Mayberry Phase 1
Amendment to the Ellicott Town Center
Phase 1 PUD/Preliminary Plan
Transportation Memorandum
PCD FILE NO.: PUDSP219
(LSC #S214300)
January 3, 2022

LSC Responses to PCD-ENG Traffic Comments

Number: 1 Author: jchodsdon Subject: Text Box Date: 2/17/2022 07:35:47
LSC Responses to TIS redline comments (2-17-2022)

TYPICAL MINOR COLLECTOR ROAD SECTION
(MINOR COLLECTOR)
SCALE: 1"=5' H
1"=2.5' V

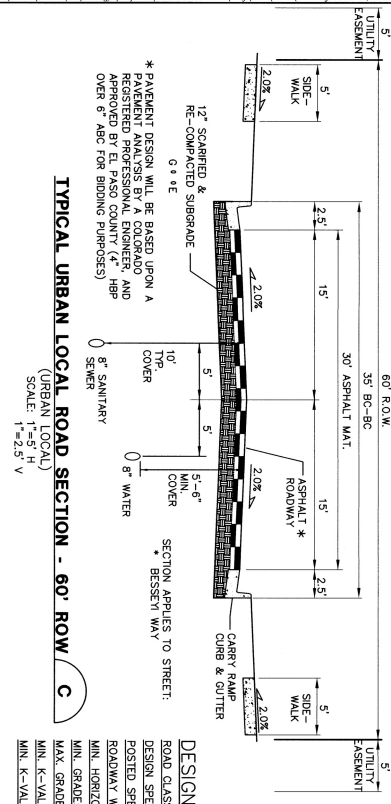
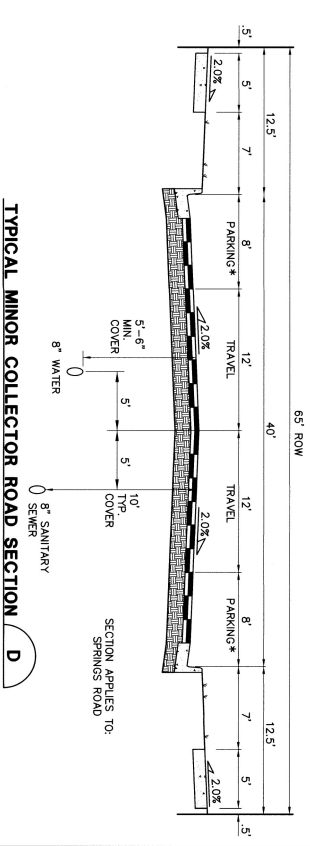
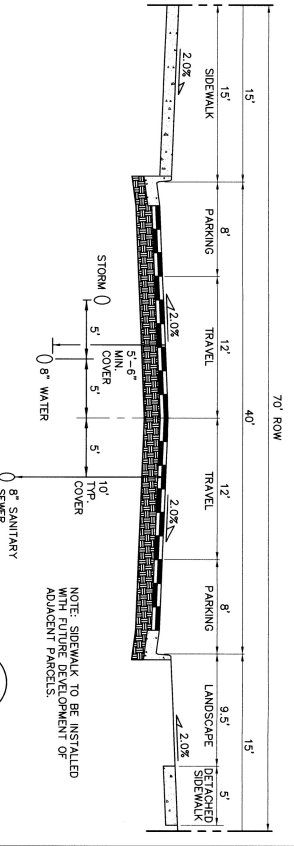
- **Mayberry Boulevard** is classified as a Collector. The approved deviation consists of modified cross-section elements including a 29-foot median and a Phase 1 half-section with a 29-foot asphalt width. **PROPOSED CHANGES: The interim section will not be on the Village Main Street alignment. It is planned to be gravel, in accordance with the design attributes of this roadway will be required to meet Collector standards.**

ADT is not the only metric when determining classification. This roadway links the local roads of the residential and commercial areas to Hwy 94 (arterial) as indicated in the description of residential/non-residential collector roadway in ECM 2.2.4. After internal discussion with staff, at minimum the minor collector classification should extend from hwy 94 to the south boundary of filings 2/3 as done before. Please revise accordingly. As stated in the previous review comment, the design attributes of this roadway will be required to meet Collector standards.

LSC Response: The TIS report has been revised to address this comment
